Recommendation Report for Lawful Development Certificate for a Proposed Use or Development

REF NO: FG/119/14/CLP

LOCATION: 46 Langbury Lane
Ferring

PROPOSAL: Application for certificate of lawfulness for a proposed single storey rear extension.

Floor Plan and Elevations

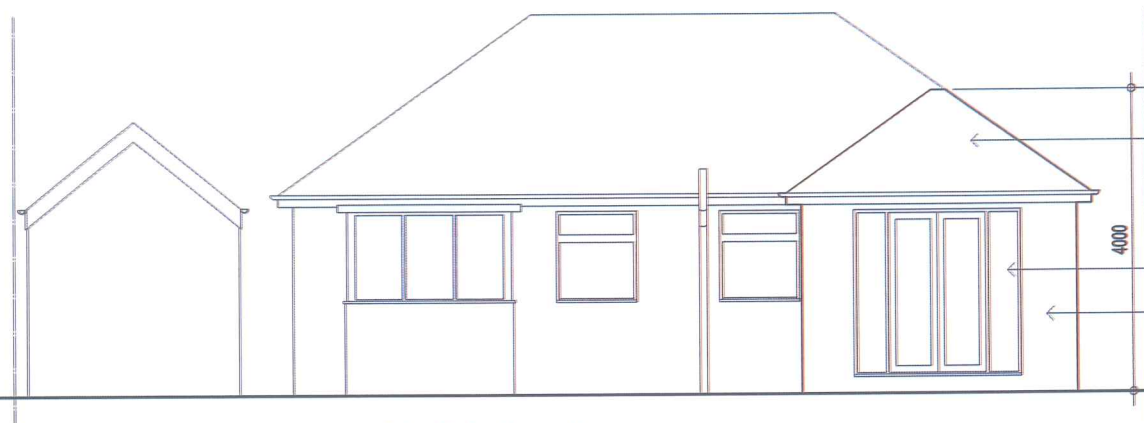
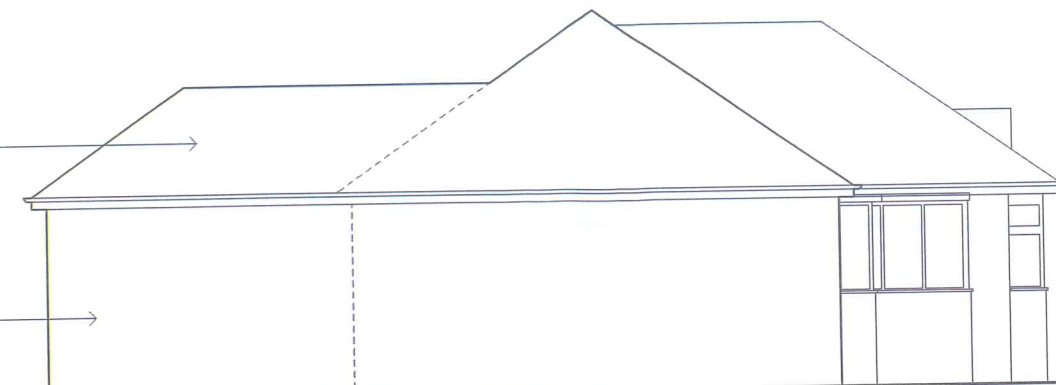
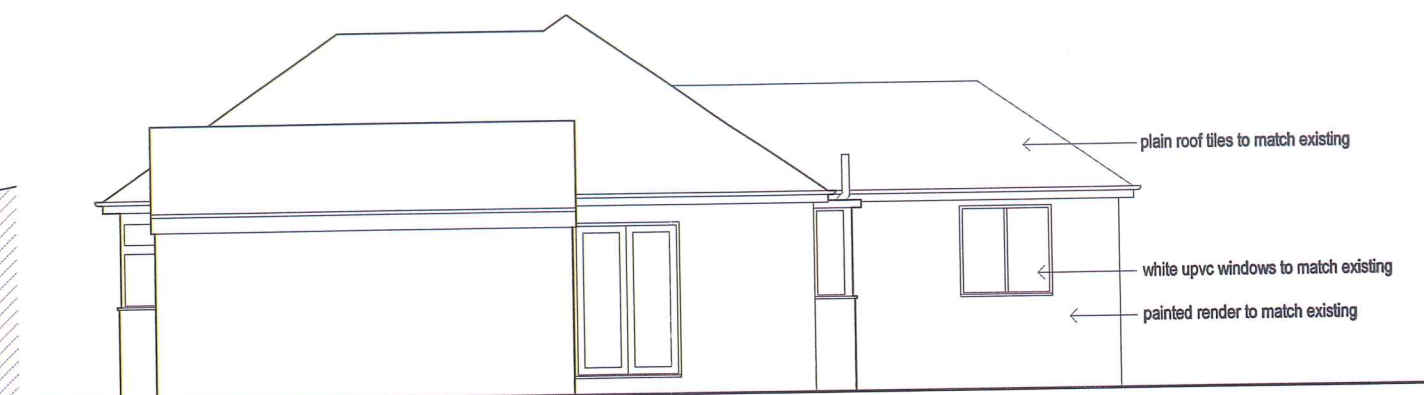
Class A.1 (b) informs that extensions must not exceed the height of the existing dwelling. The ridge height of the roof of the proposed extension will be set below that of the existing dwelling roof, in accordance with this criterion.

Class A.1 (c) states that the eaves height of the extension must not exceed those of the dwelling. The eaves height of the proposed extension matches that of the existing roof and the works therefore conform with this requirement.

Class A.1 (e)(i) and (ii) assert that an extension to a detached dwelling (such as the proposal) should not project more than 4 metres from the rear wall of the original dwelling. The proposed extension will project 4 metres from the rear of the dwelling and, therefore, does not exceed the threshold. This criterion also sets the maximum height of a single-storey extension as 4 metres. The ridge height of the proposed extension will be 4 metres above ground level and is therefore acceptable.

Class A.1 (g) maintains that an extension within 2 metres of any site boundary should have an eaves height of no greater than 3 metres. The proposed extension will be within 2 metres of the western site boundary. At 2.5 metres, the eaves height of the proposal is within this parameter.

Conditions to any Permitted Development are imposed under Class A.3. Only criterion (a) is applicable to this application. This condition requires external materials used for any extension to be similar to those of the existing dwelling. It is stated on the plans accompanying the application that matching materials will be used in the construction of the extension.

Ground Floor Plan

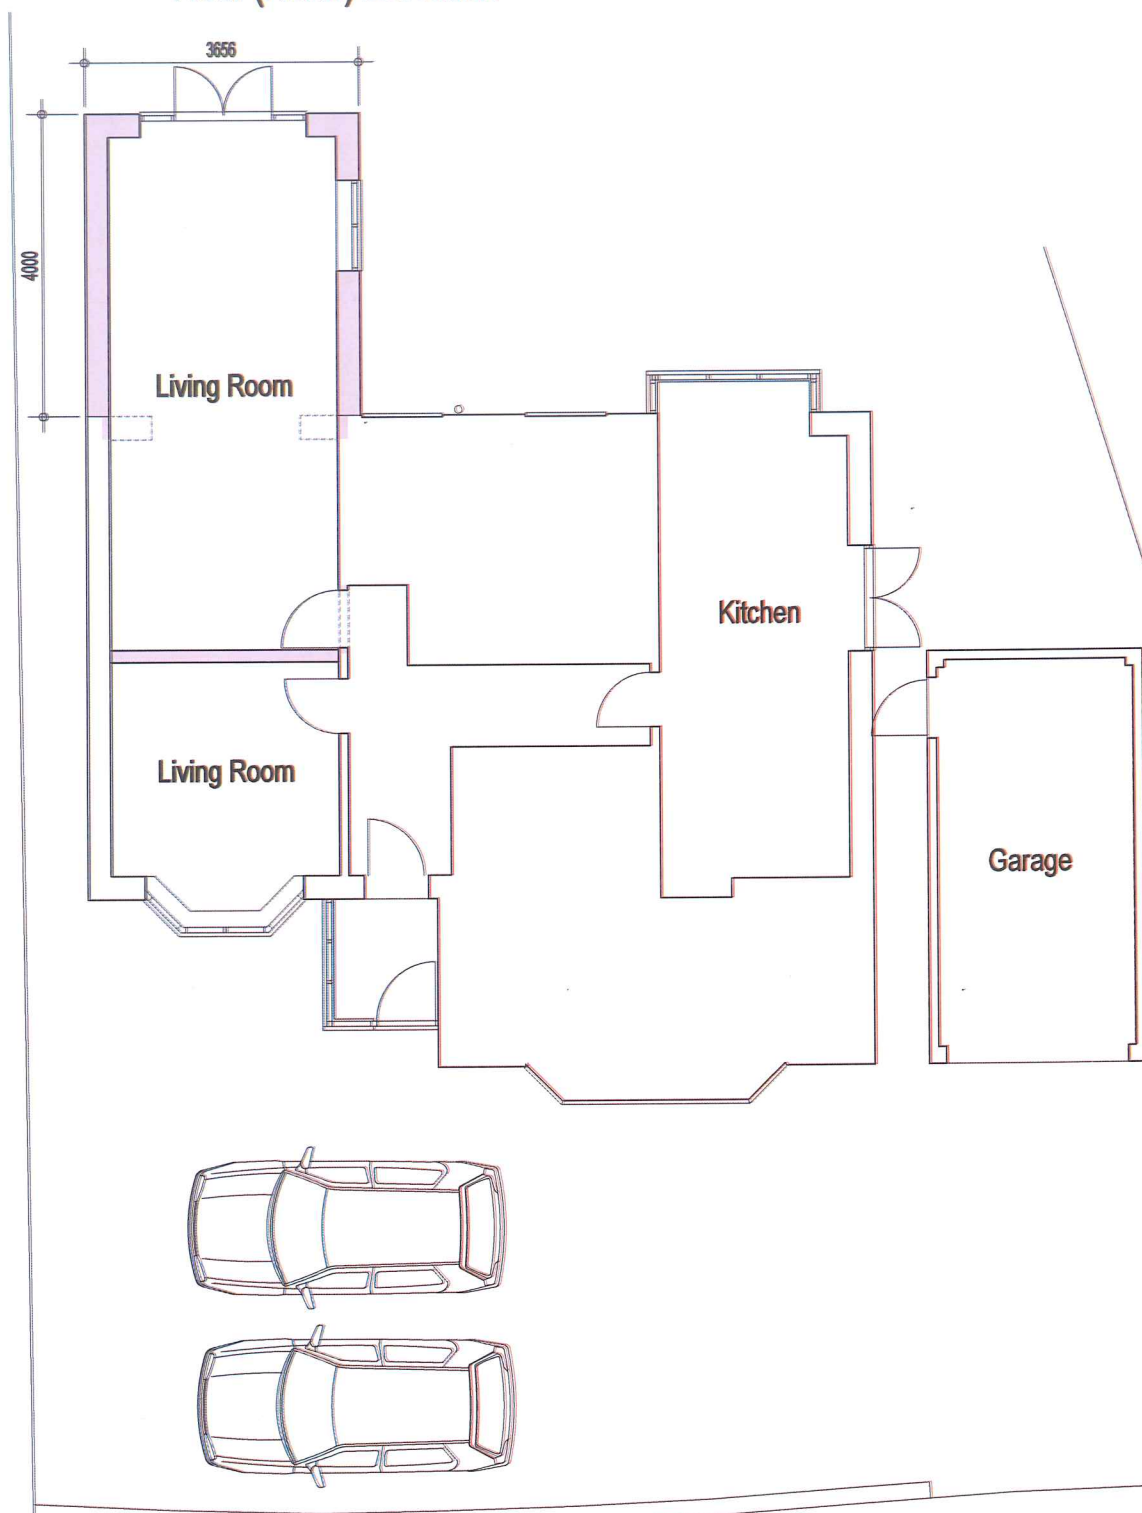
The proposed extension measures 4 metres in depth by 3.656 metres in width. Height to roof eaves is 2.5 metres whilst height to the roof ridge is 4 metres.

DRAWING
Site / Block Plan as Proposed

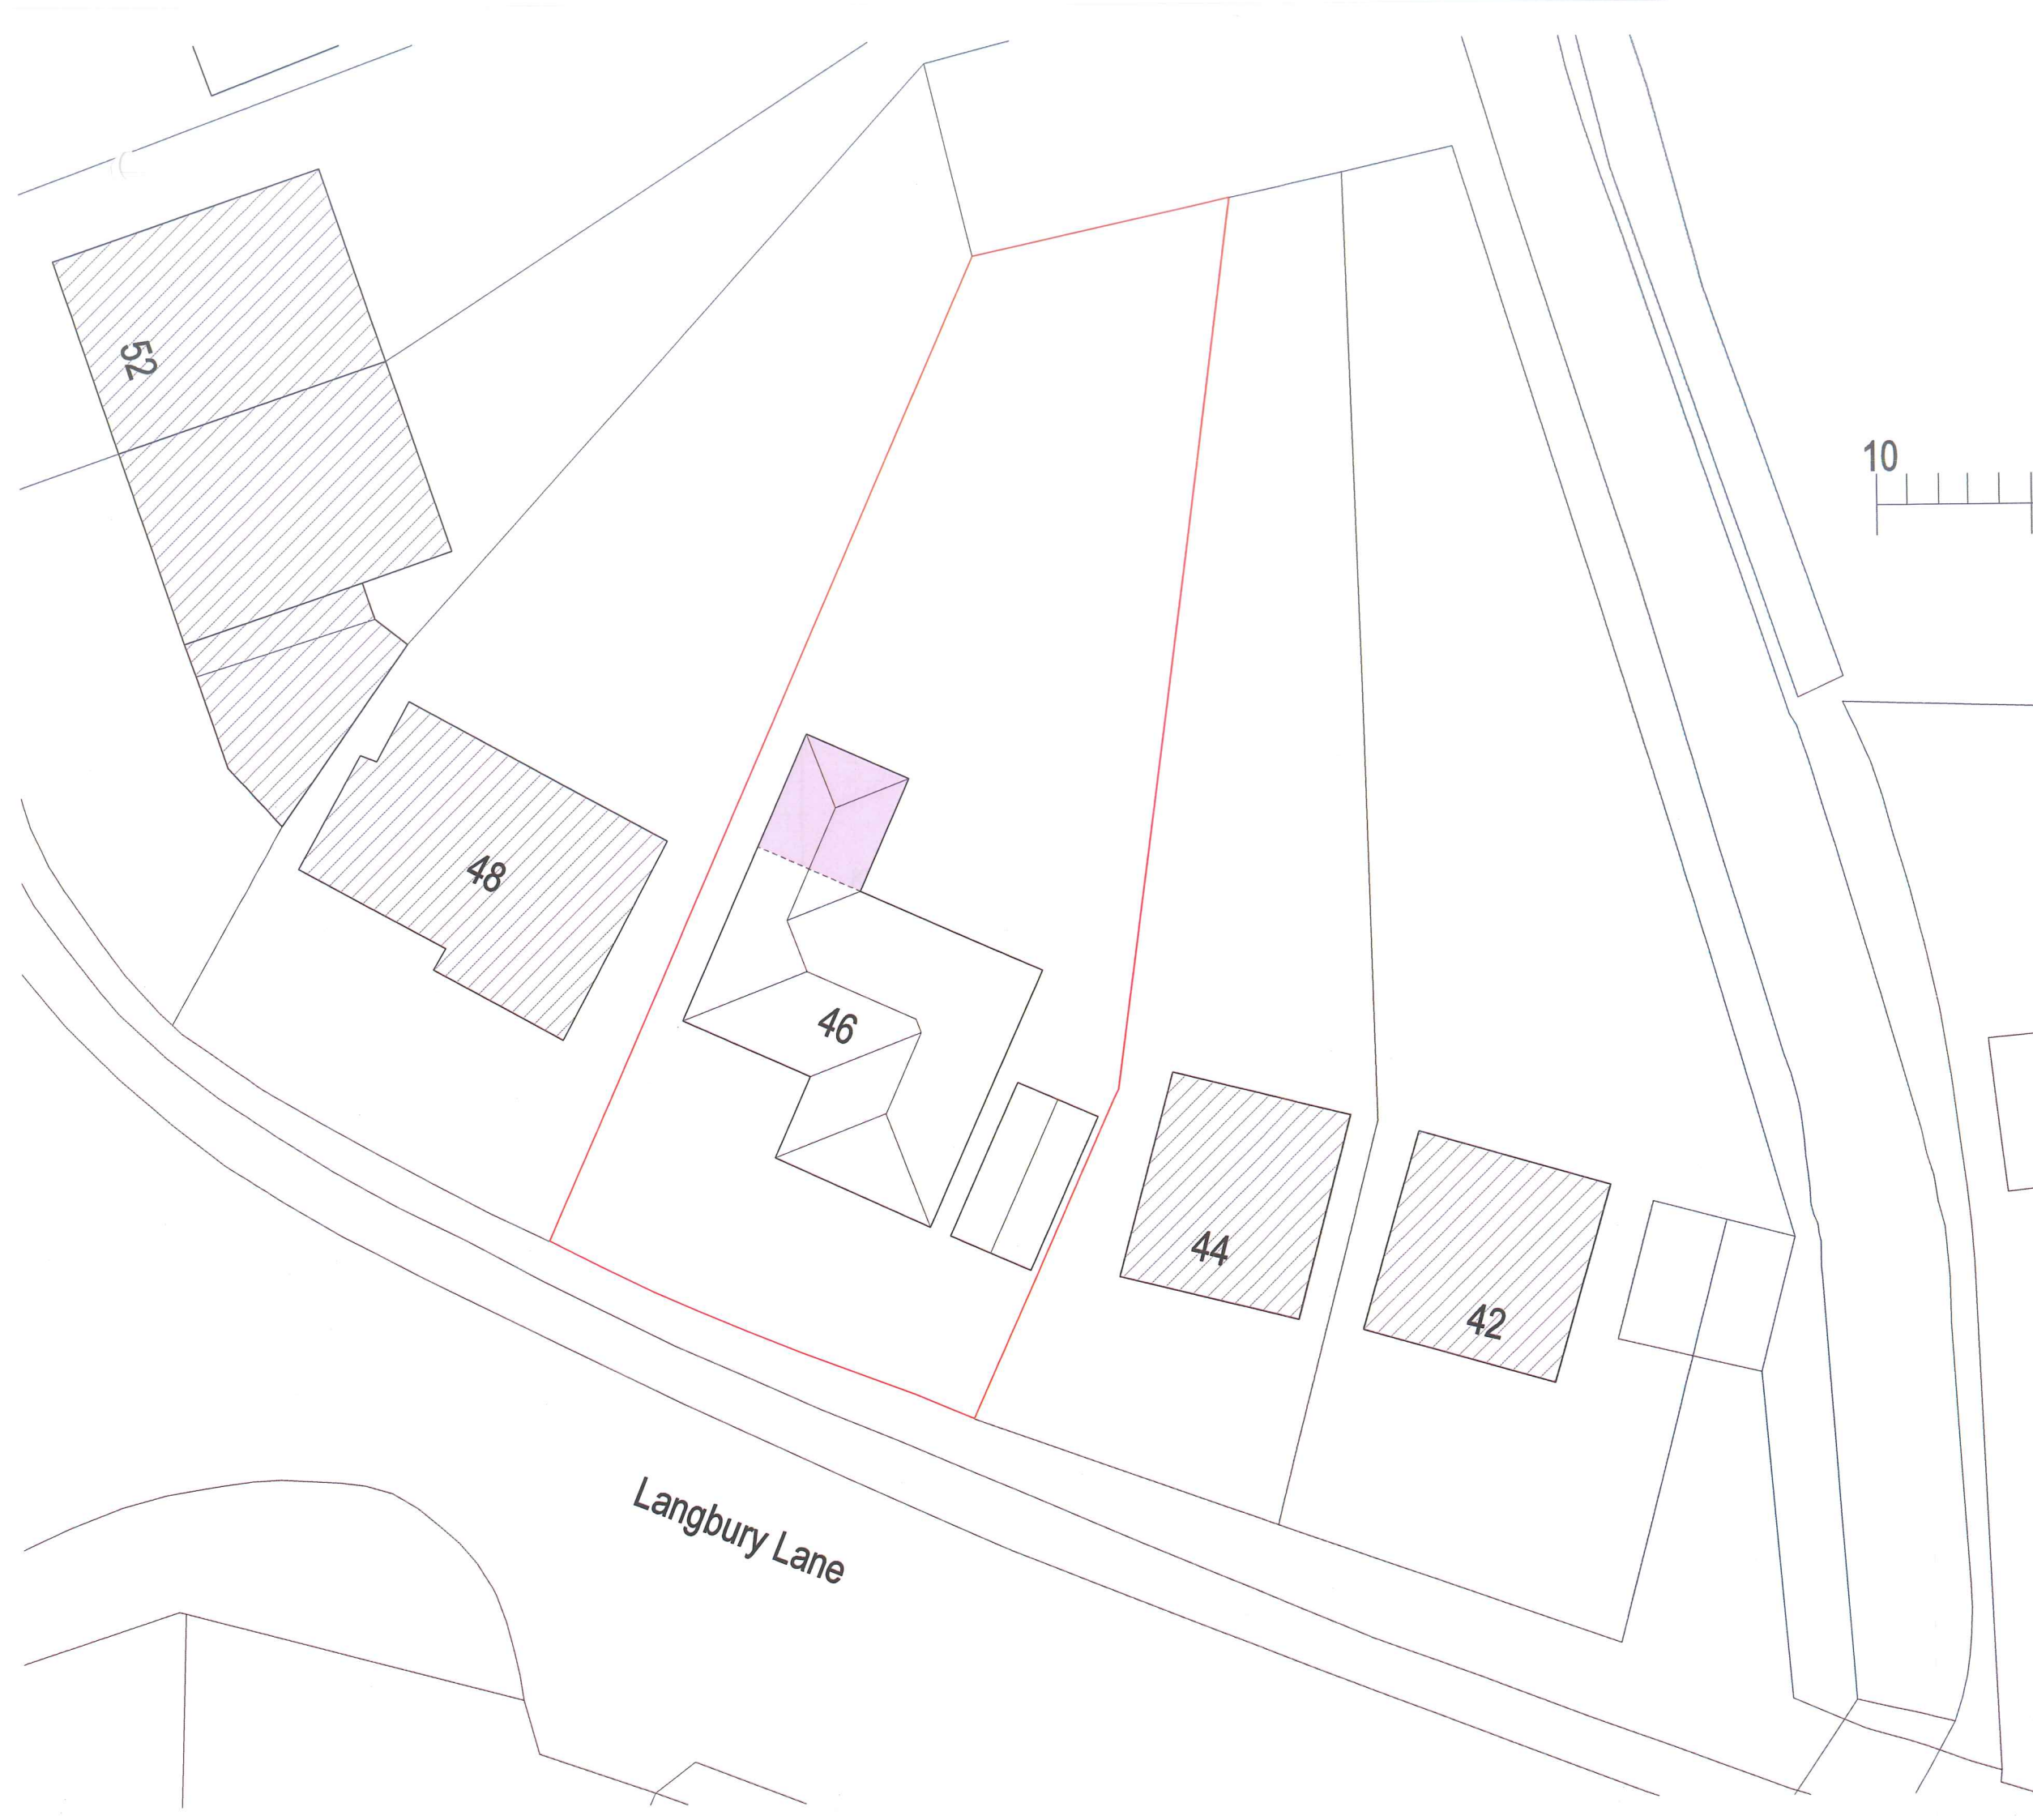
The proposal is for a single storey extension to the rear of a detached dwelling. The Town and Country Planning (General Permitted Development)(Amendment)(No. 2)(England) Order 2008 Article 3 Part 1 Class A.1 (a) states that the the cumulative amount of ground covered by any extensions should not exceed 50% of the total area of the curtilage (not including the original dwelling house). Following measurement of the site area it has been ascertained that the footprint of the proposed extension will occupy under 50% of the area of the curtilage.
